Application Ref:	3/2021/0371	 Ribble Valley Borough Council www.ribblevalley.gov.uk
Date Inspected:	02/06/2021	
Officer:	RB	
DELEGATED ITEM FILE REPORT:		REFUSAL

Development Description:	Single storey extension, external alterations and conversion of part of the garage to games room and home office.
Site Address/Location:	Skirden Hall Barn Wigglesworth Road Slaidburn BD23 4SX

north west elevation

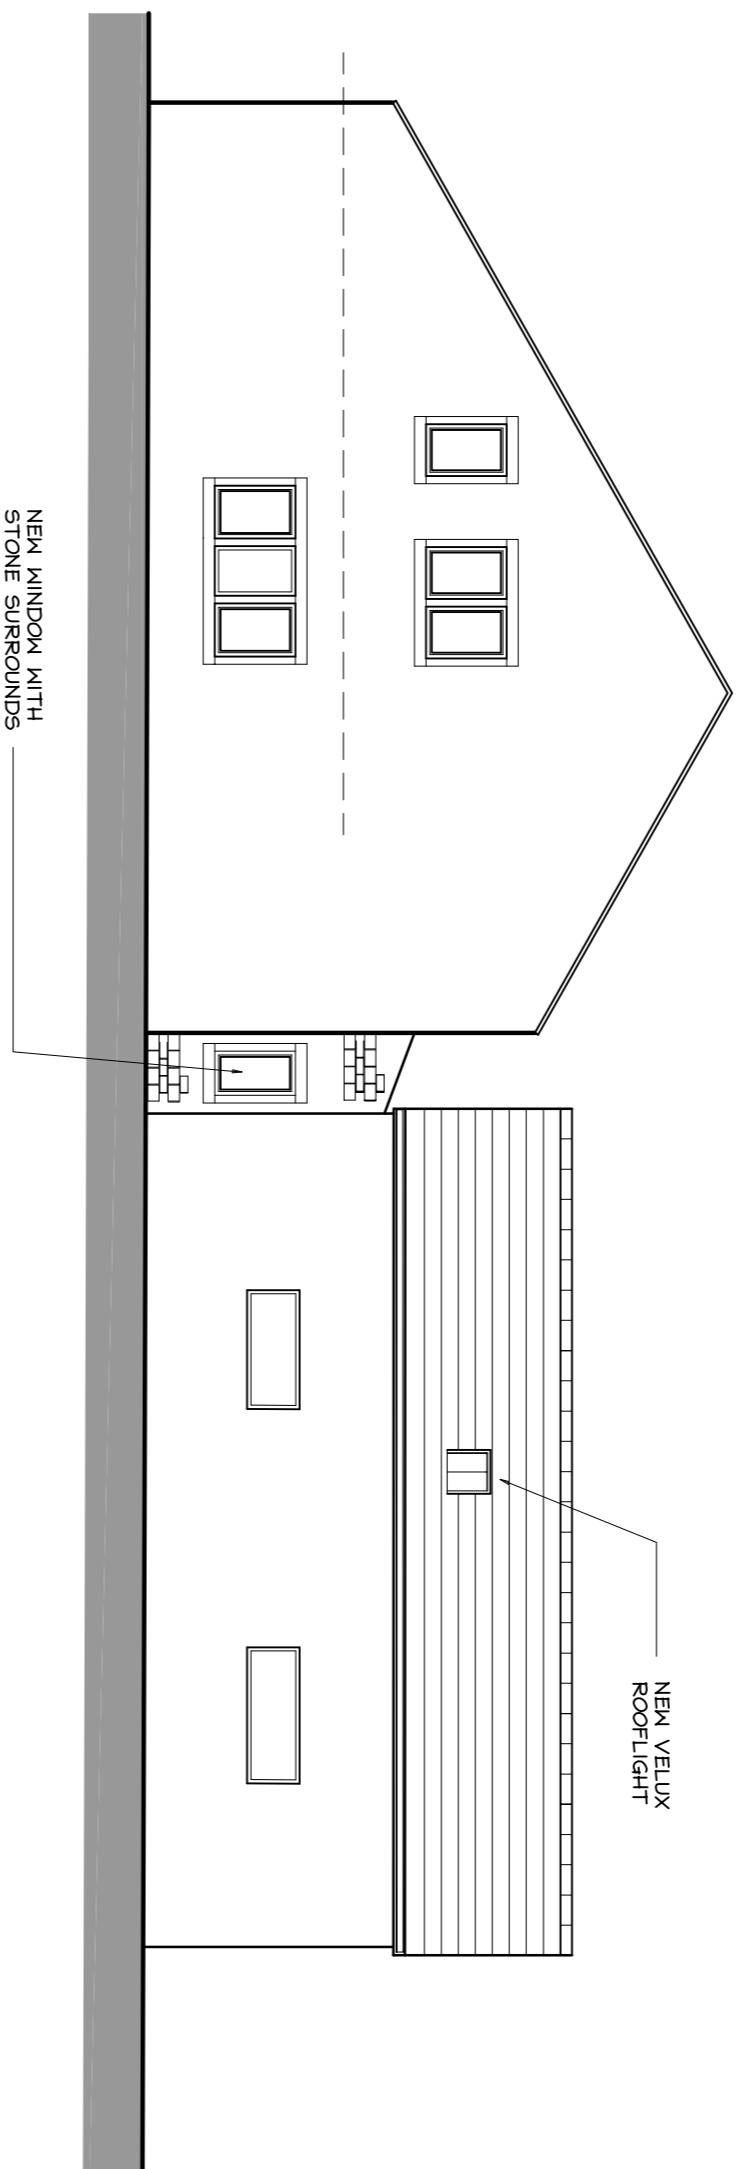
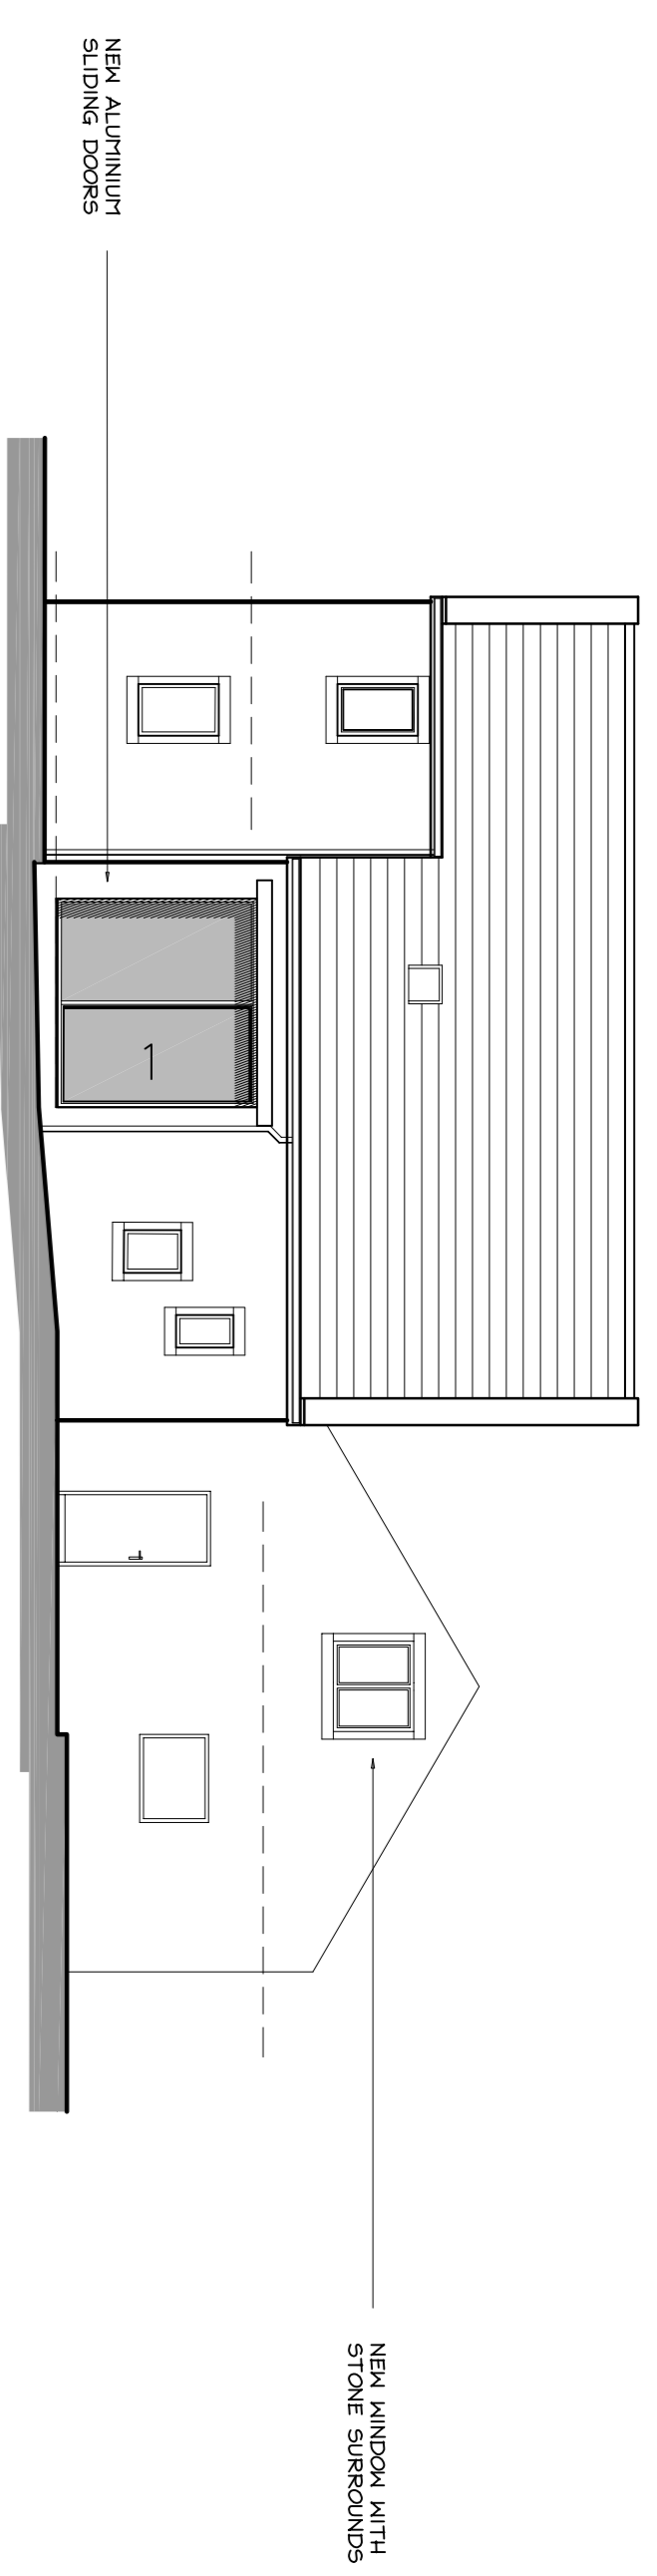
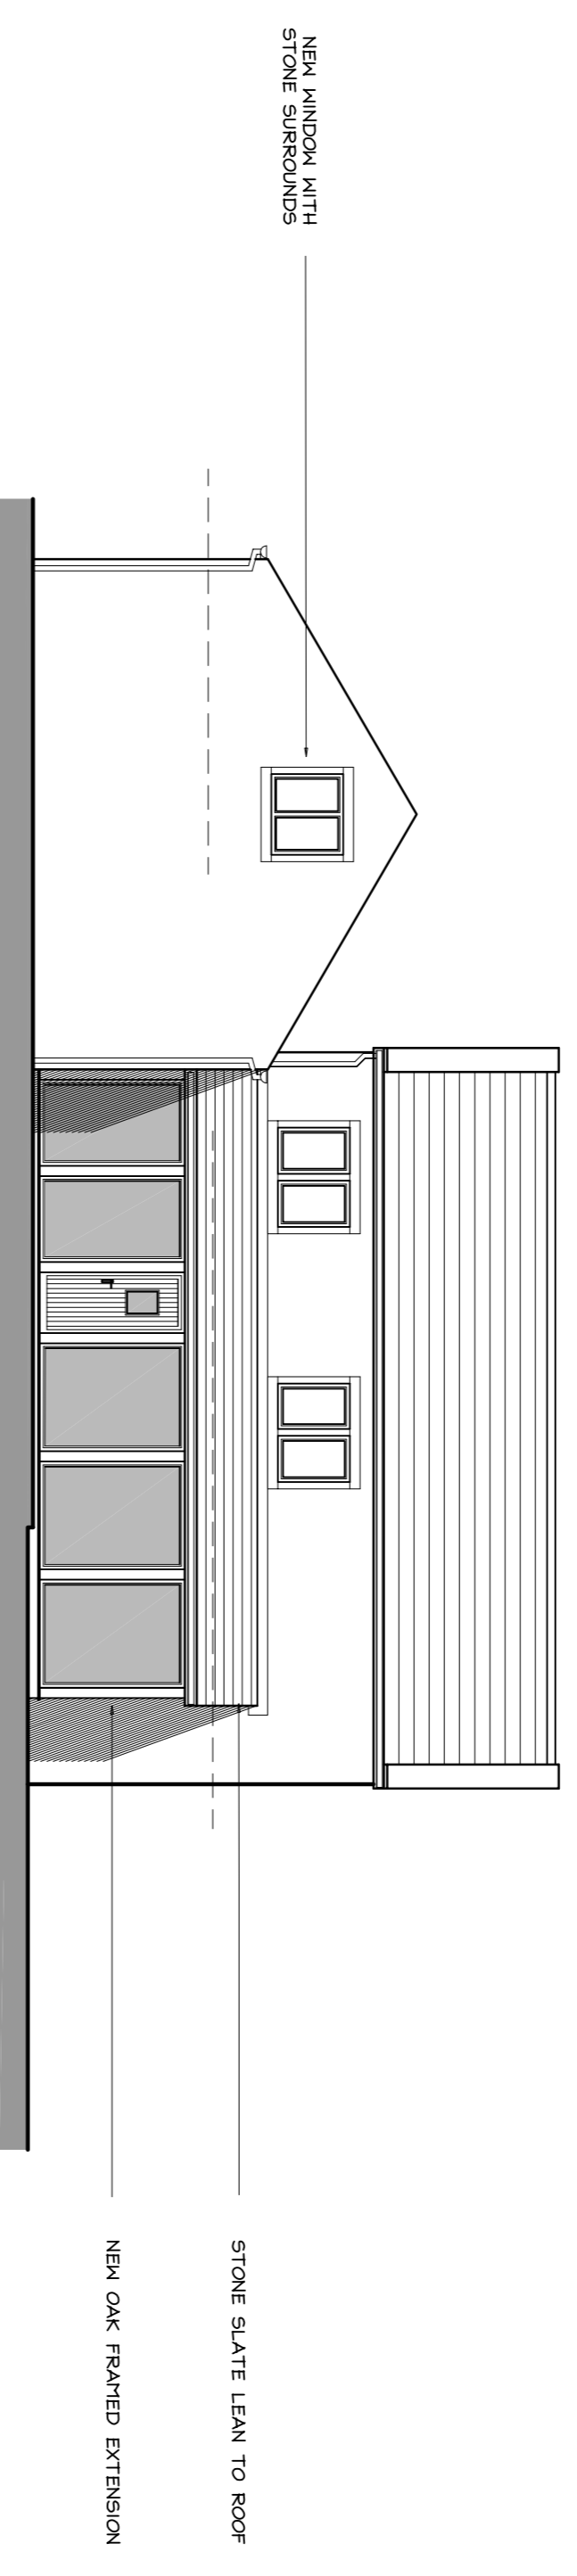
The proposed extension is to be constructed using mainly glazing with an oak frame. The roof of the extension will be slate to match the barn roof. It is considered that the proposed development would result in a significant amount of glazing at ground floor on an elevation where the openings have been limited to three at ground floor. With approximately half of the elevation having no openings at ground or first floor. The introduction of such a significant amount of glazing is inappropriate considering that most agricultural barns benefit from a minimal number of openings.

Considering the above the proposed extension would result in significant harm to the character of this traditional farm building and would neither conserve nor enhance its inherent character. The extension would impact the simple and traditional character of the barn by creating an inappropriate and incongruous extension. As a result the development would also be harmful to the character of the Forest of Bowland AONB.

RECOMMENDATION:	That planning consent be refused for the following reason(s)
01	The proposed development, by virtue of its design and elevational language, would result in an unsympathetic and discordant addition that would be harmful to the character and appearance of the host building and the surrounding area contrary to policies DMG1 and Policy DMH5 of the Ribble Valley Core Strategy.
